**Our ref:** NO/2019/112169/01-L01  
**Your ref:** 3/2019/0930

**PROPOSED EXTENSION TO FACTORY AND CREATION OF NEW CAR PARK WITH ACCESS.  
CLITHEROE LIGHT ENGINEERING, UNITS A-C, UPBROOKS INDUSTRIAL ESTATE, CLITHEROE, BB7 1PL**

**Environment Agency position**

PROPOSED SITE PLAN

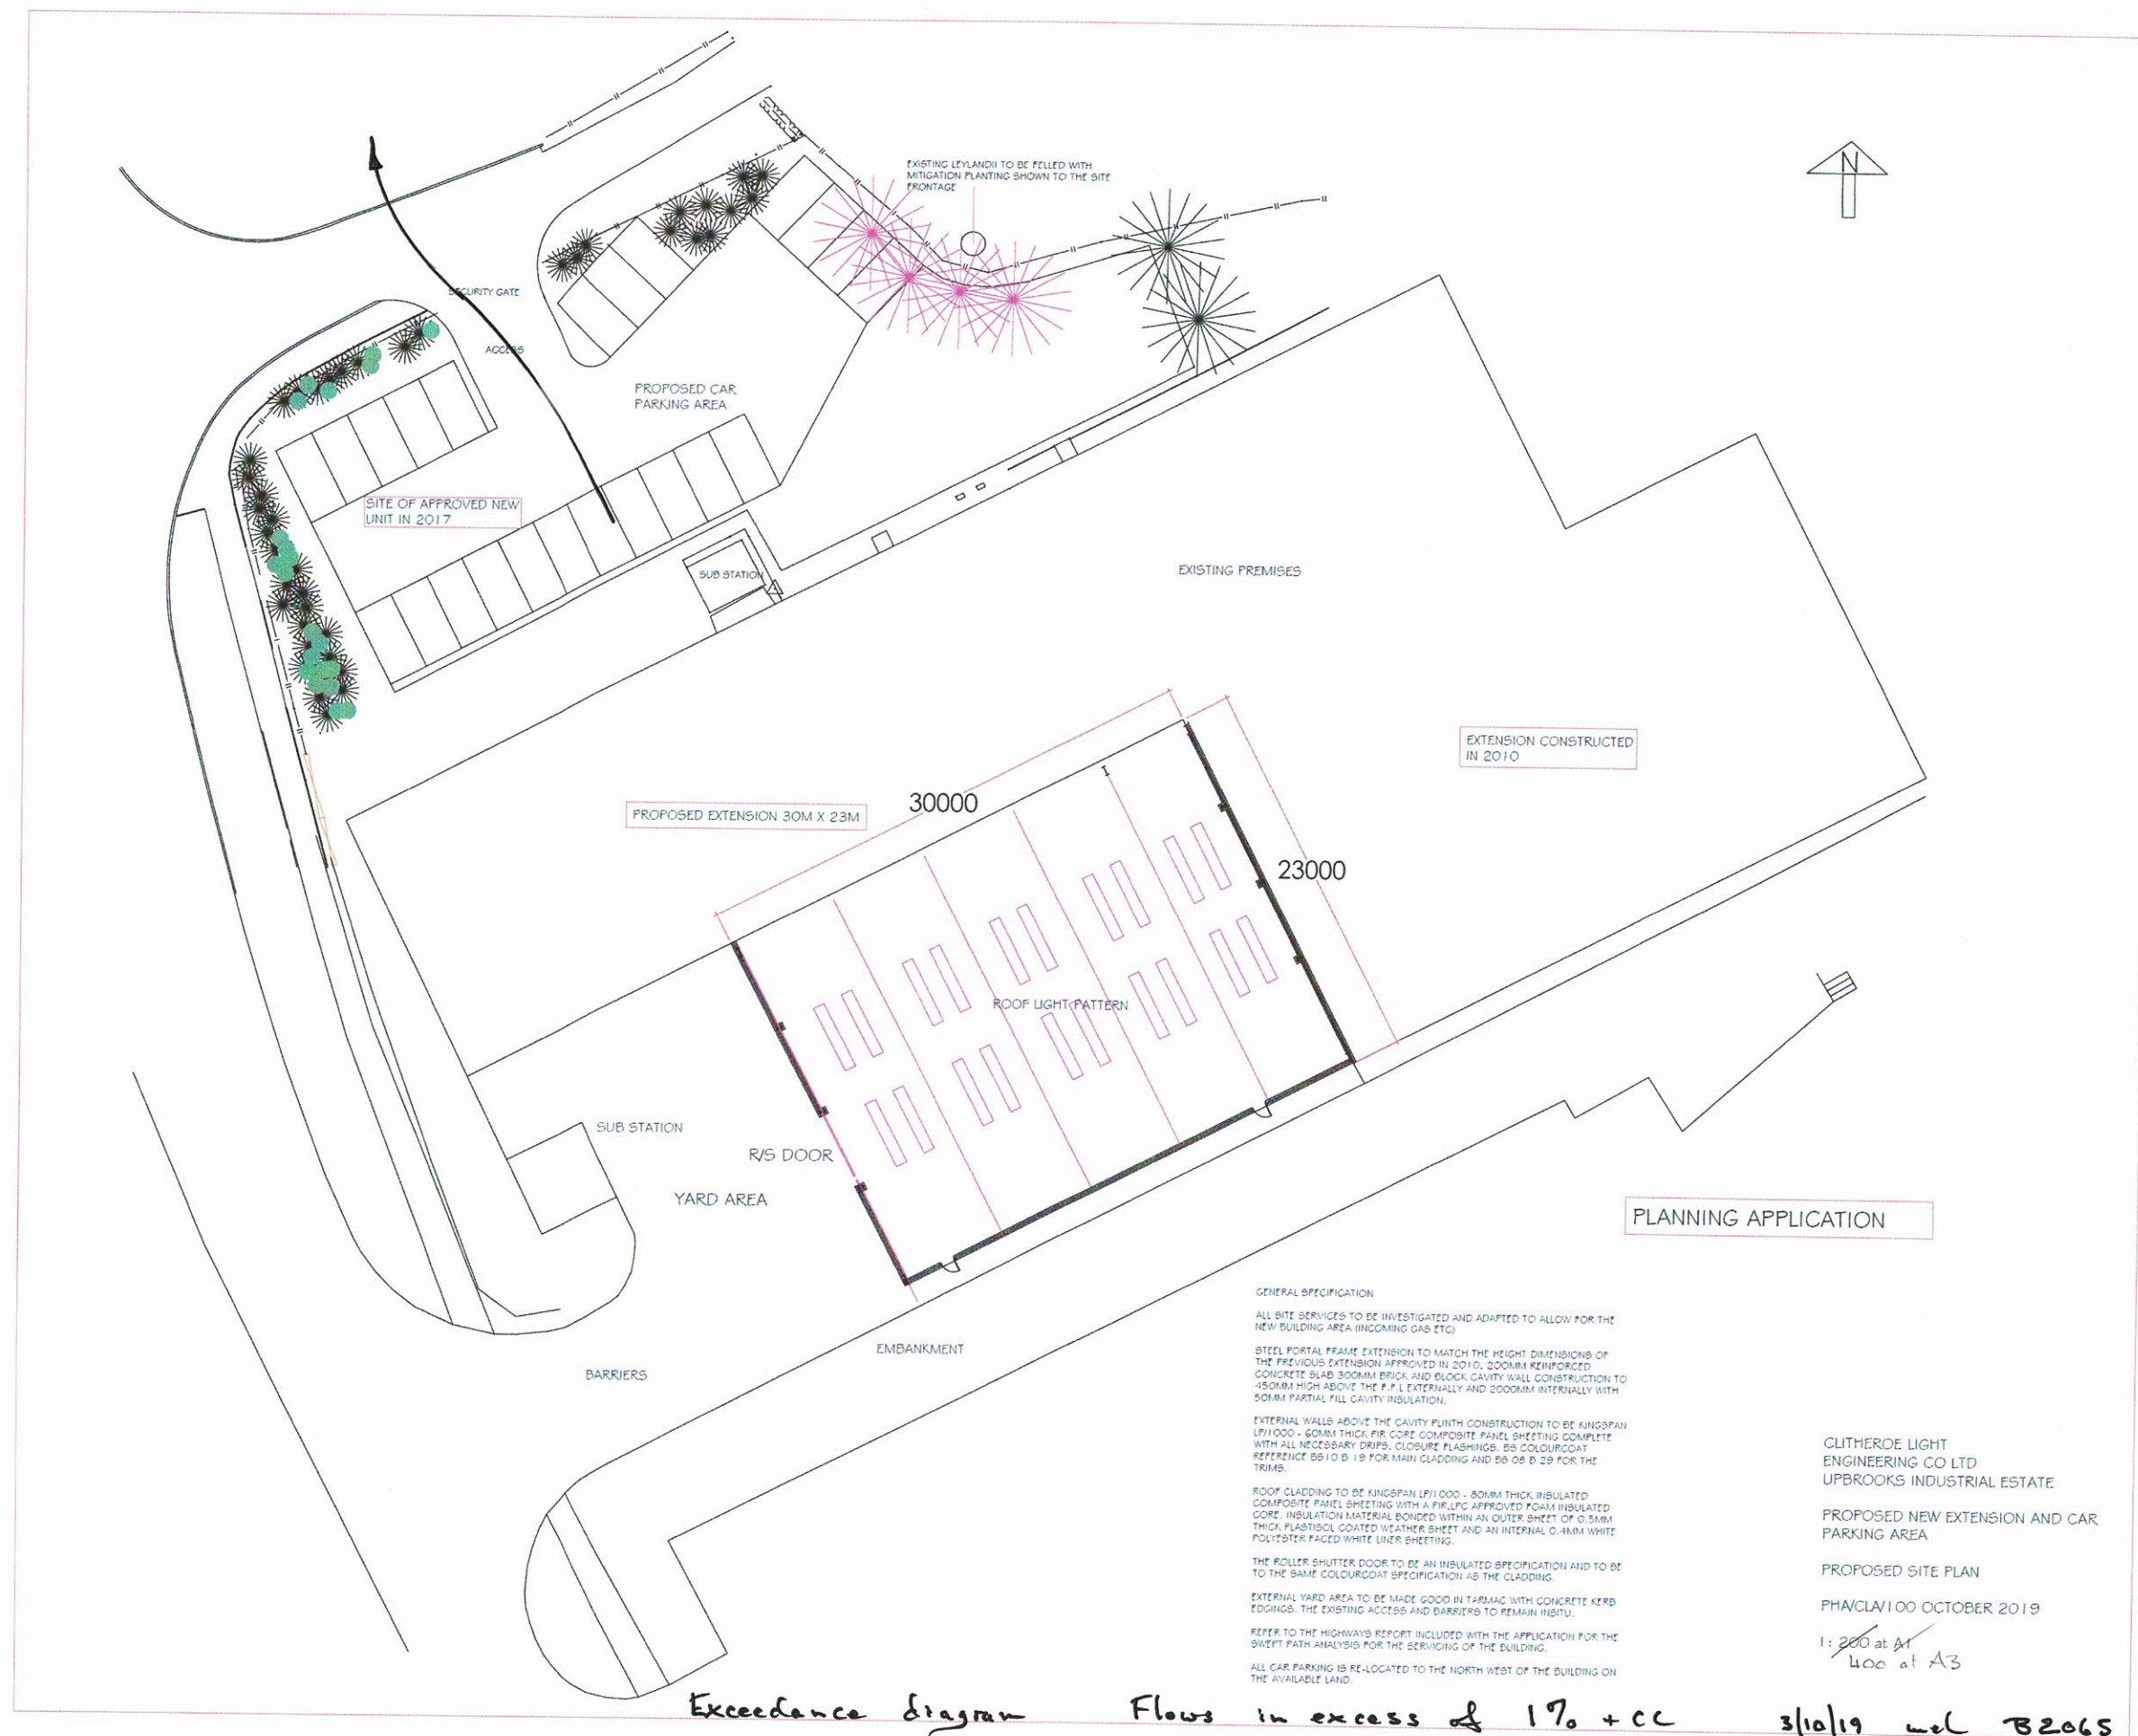
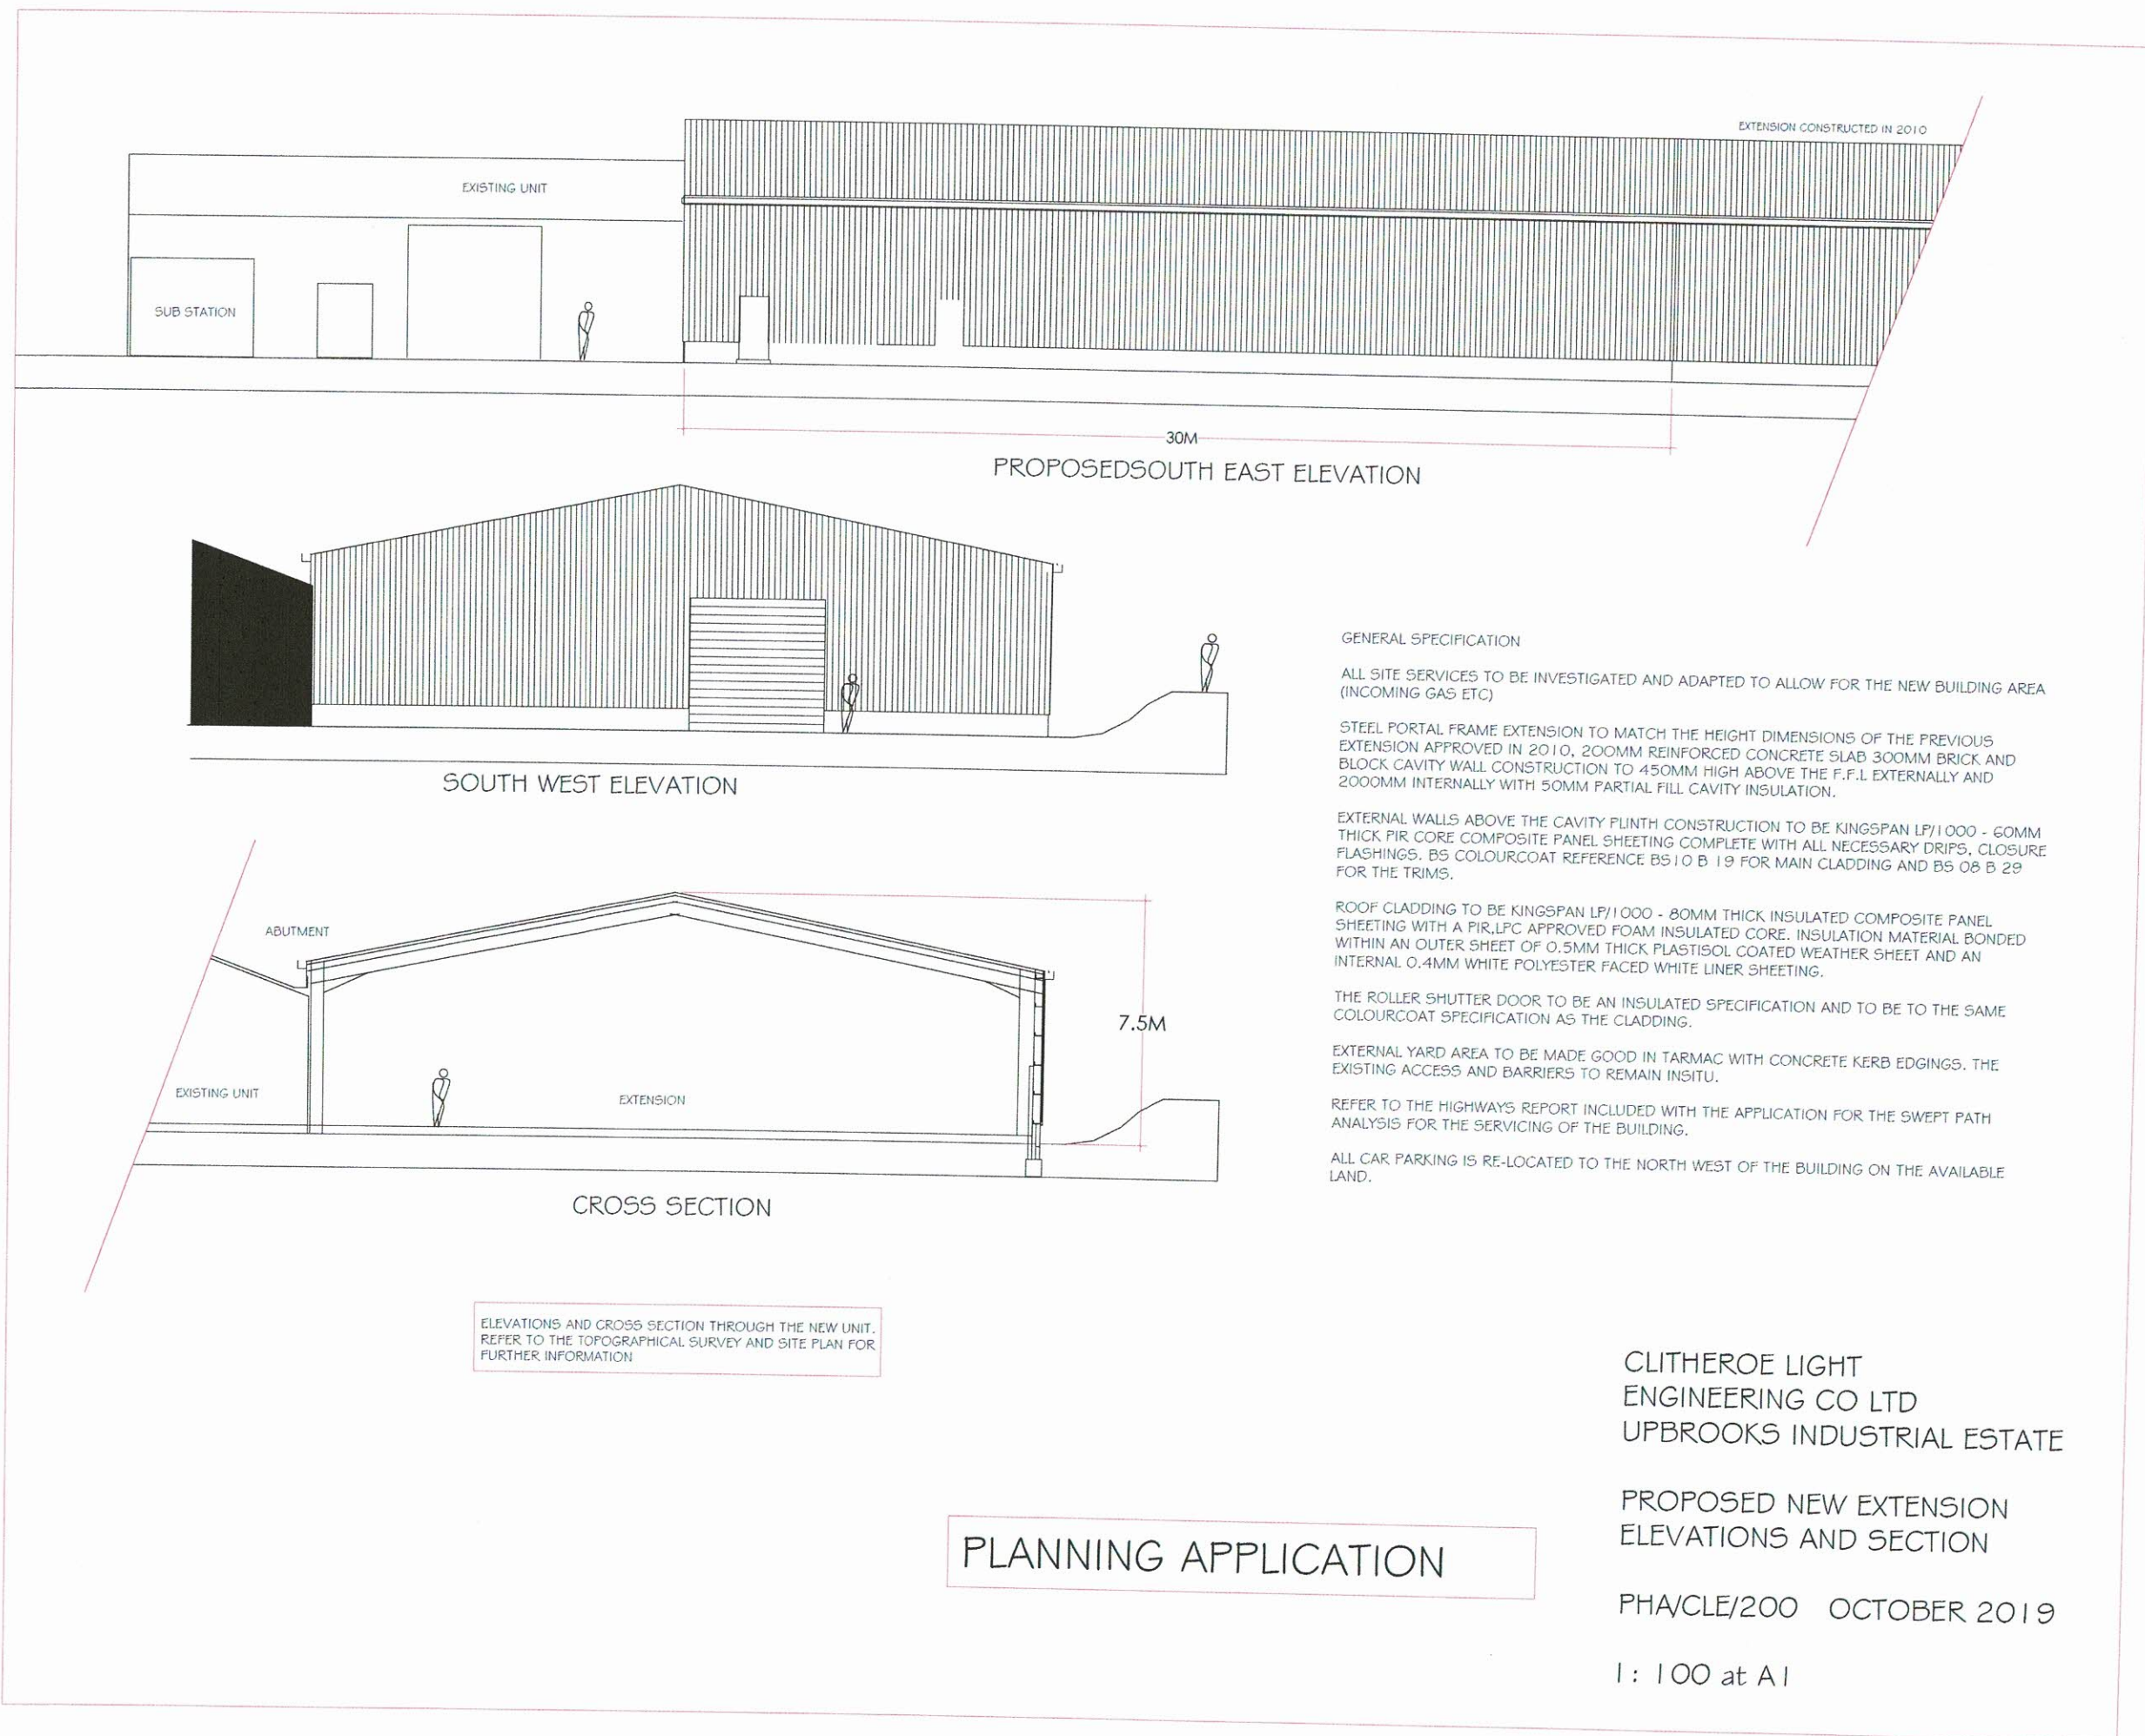
The FRA does not therefore, adequately assess the development's flood risks. In particular, the FRA fails to properly demonstrate that the floodplain will not be infilled by the proposed car park.

- \* a topographic survey to Ordnance Datum.
- \* a proposed car park layout which demonstrates that the proposed ground levels of the car park are the same as existing ground levels, thereby demonstrating that the floodplain will not be infilled and that flood risk to adjacent properties will not be increased.
